From: Maria Tomalova <Maria.Tomalova@arun.gov.uk>
Sent: 03 March 2021 10:15
To: Planning.Responses <Planning.Responses@arun.gov.uk>
Subject: FW: Application Y/151/20/PL

From: Ian Stocks [REDACTED] **On Behalf Of** FRS Water and Access
Sent: 01 March 2021 13:59
To: Maria Tomalova <Maria.Tomalova@arun.gov.uk>
Subject: RE: Application Y/151/20/PL

Scheme **Eric Wall Nursery, Lake Lane, Barnham, PO22 0AD**
Title **Proposed Site Plan (2 of 2)**

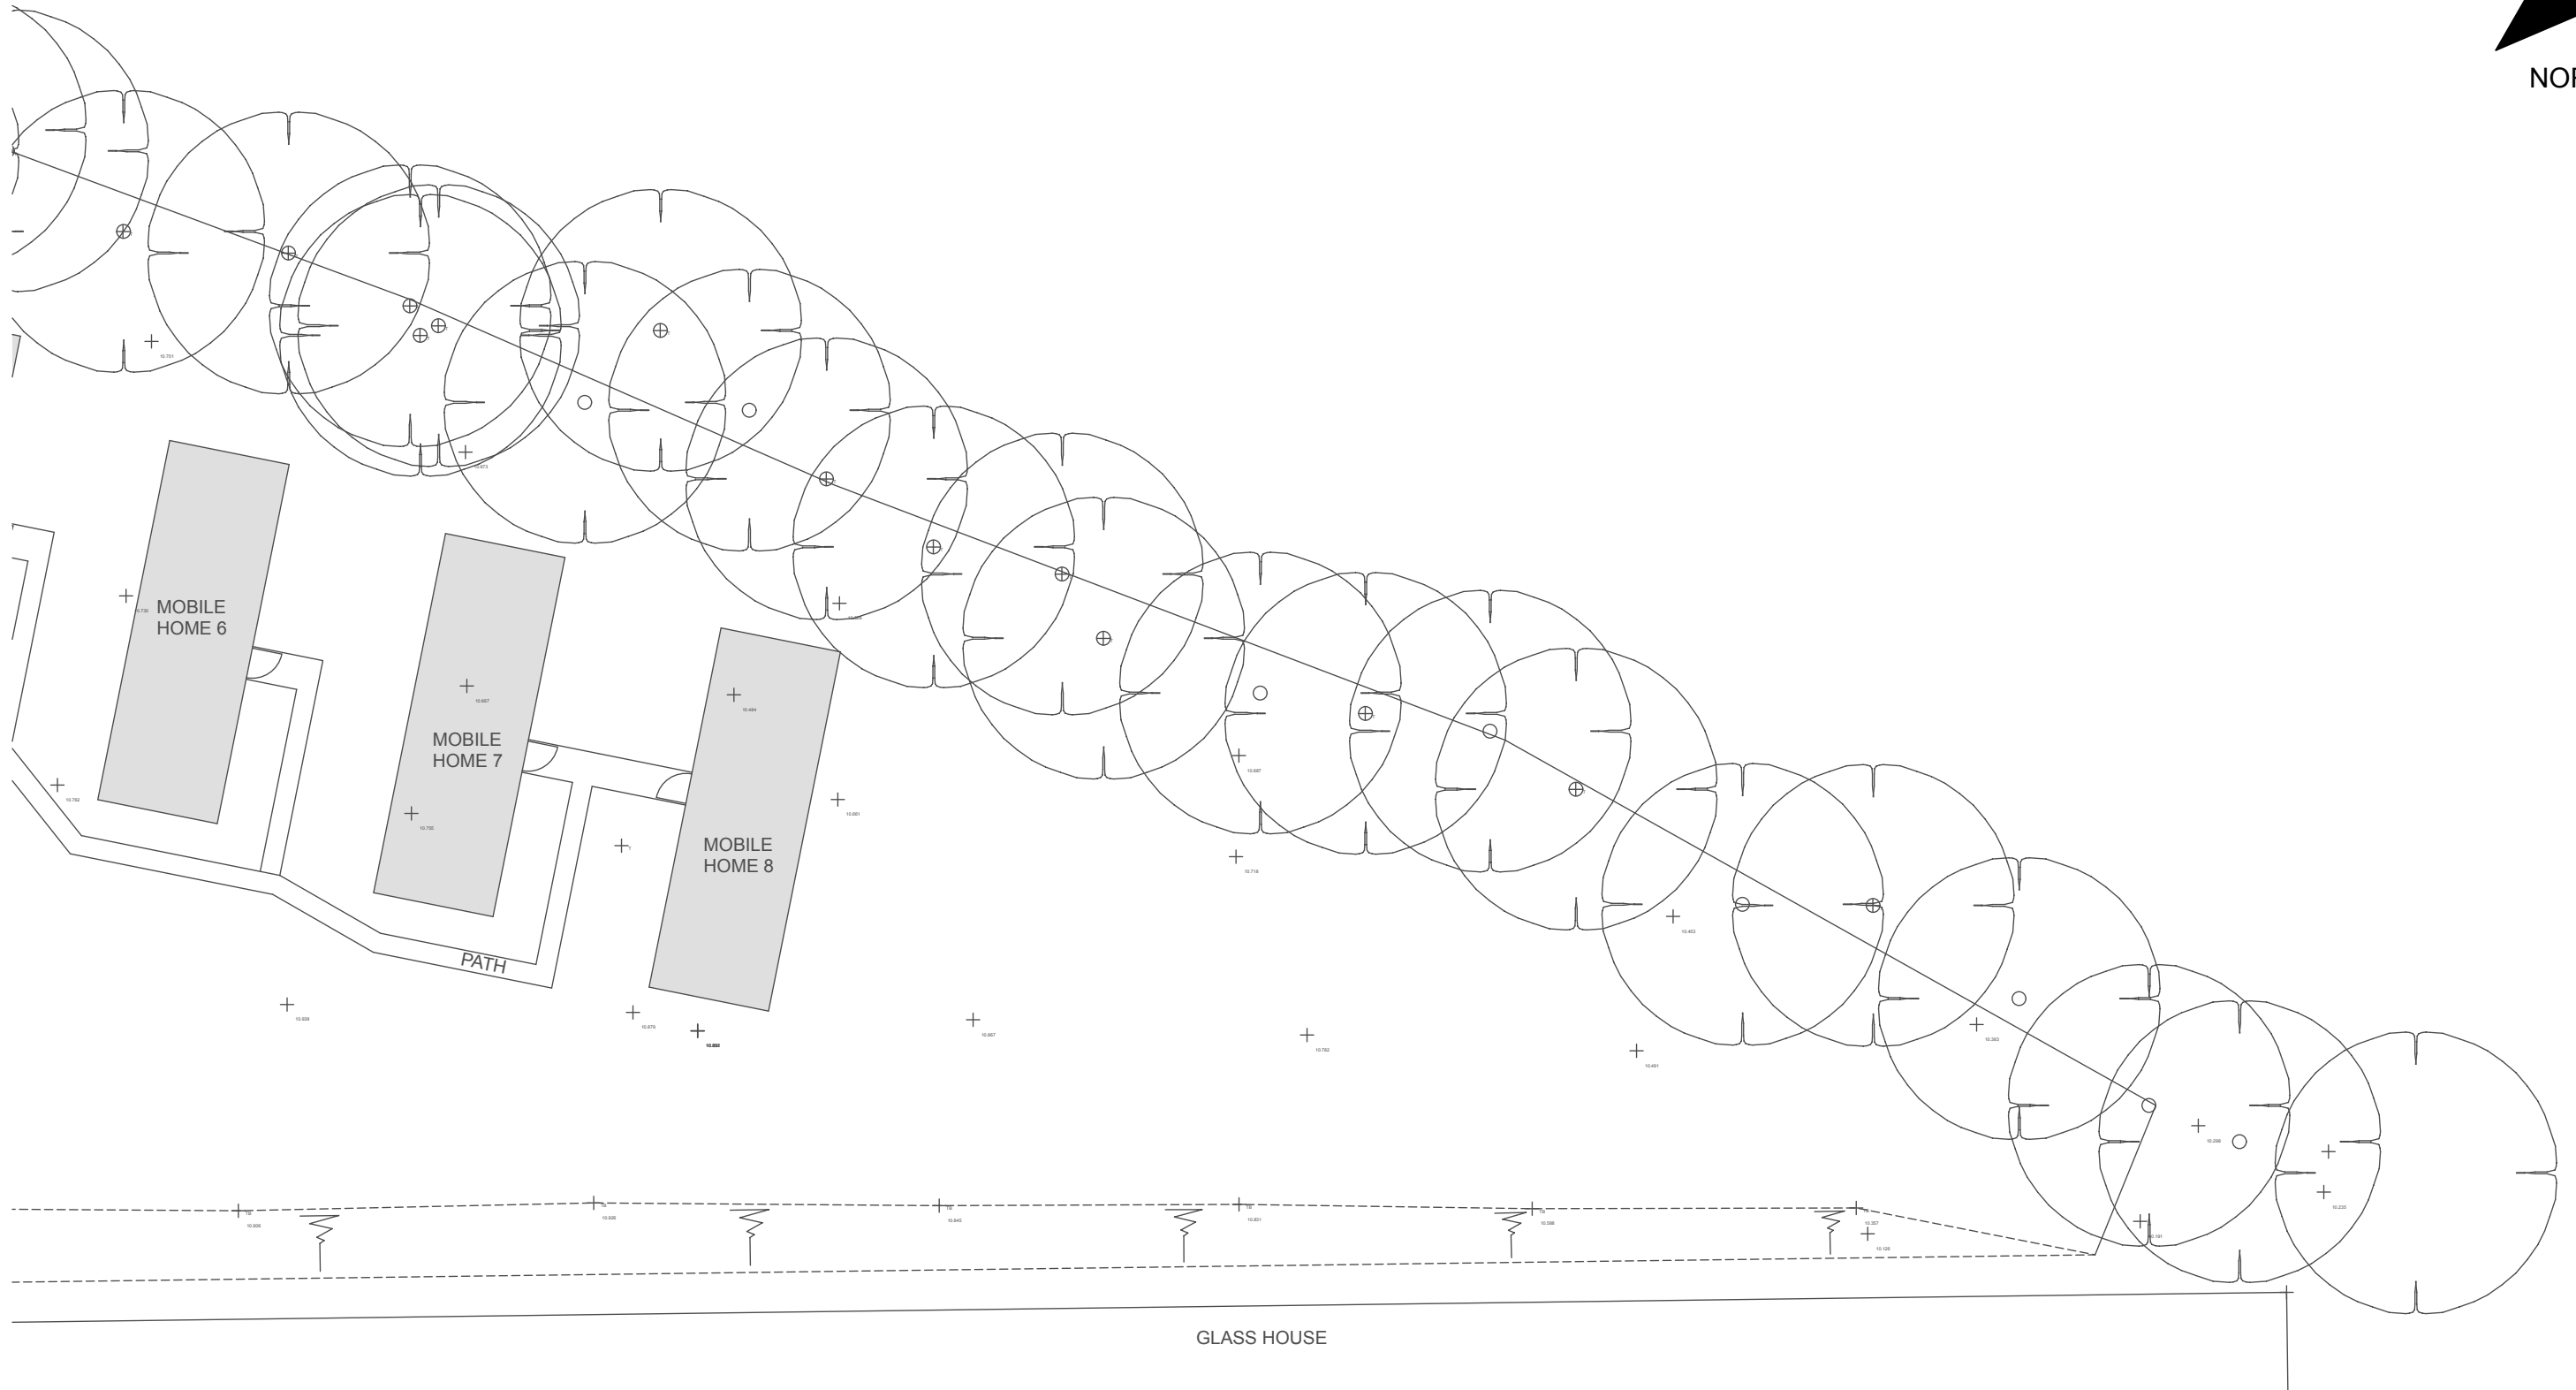
The size and location of the alternative water supply looks like it would meet with the requirements, we will need is evidence of suitable access and a hard standing area for a fire appliance to enable the water to be extracted and used to extinguish a fire. Also evidence will

be needed to show the access from the reservoir to the accommodation area containing 8 mobile homes and that they are within the required distance. There is a fire hydrant out on lake lane within 90 metres of this area but there is no access route from the road to enable it to be used.

The other 3 mobile homes appear to be within 90 metres of the other reservoir, once again providing there is a suitable position for the water to be extracted.

With respect to water availability for the fire service, the applicant has confirmed the reservoir which lies to the west of the proposed units (see attached location plan) holds 144,000 litres of water. The Health & Safety Manager on site has confirmed it will be possible to utilise this resource and that the reservoir has sufficient capacity to tackle any fire on site.

Fire Engine Swept Path - Part 1

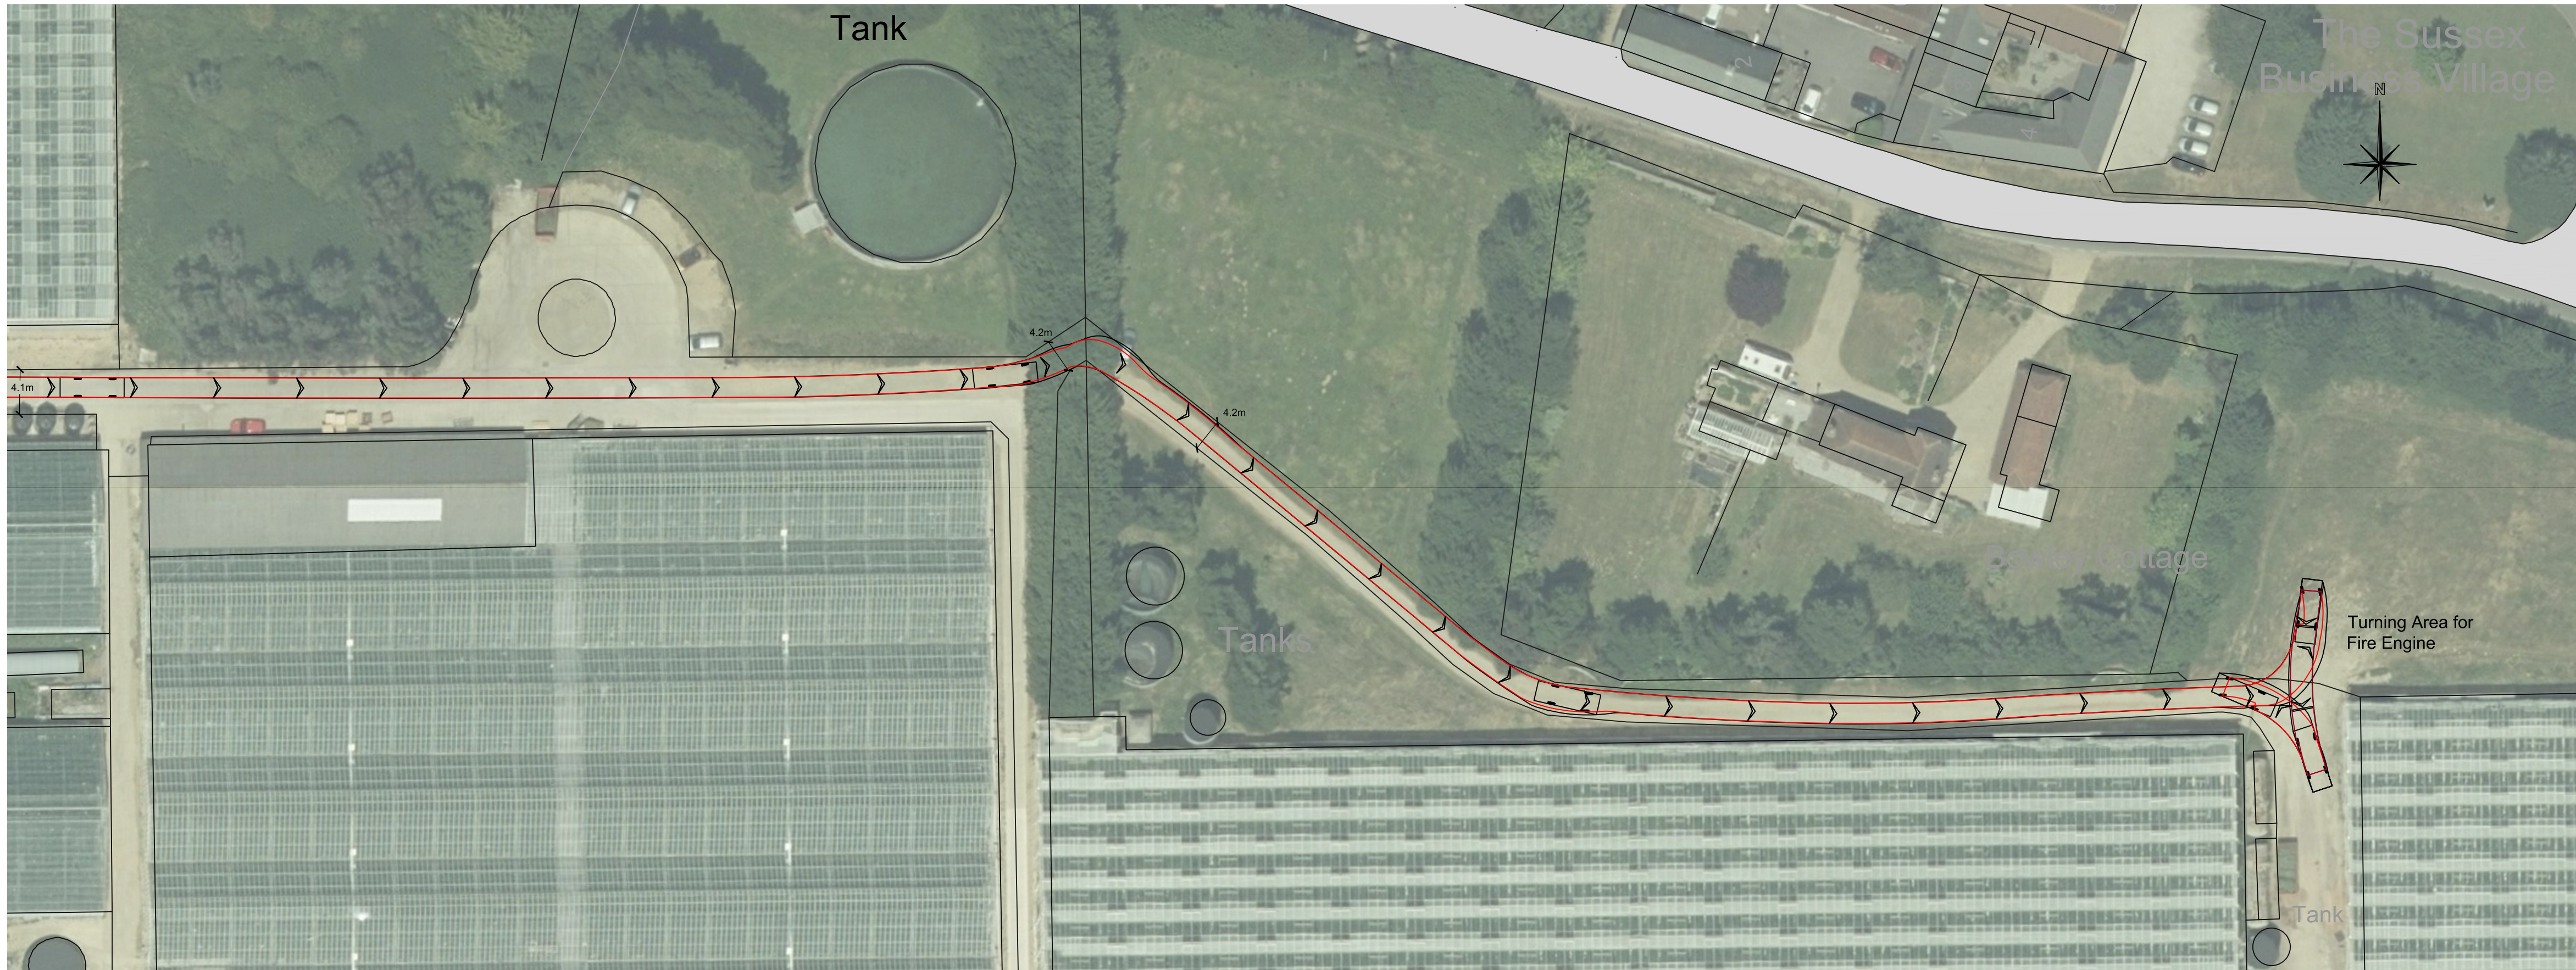
Thank you for your email.
I am afraid you should provided an evidence showing suitable access as required by Fire
And Rescue Service.

Thank you for your email. I have advised the client a swept path analysis is required, and we are seeking a fee quote to have this work undertaken ASAP. Will let you know once this is undertaken.
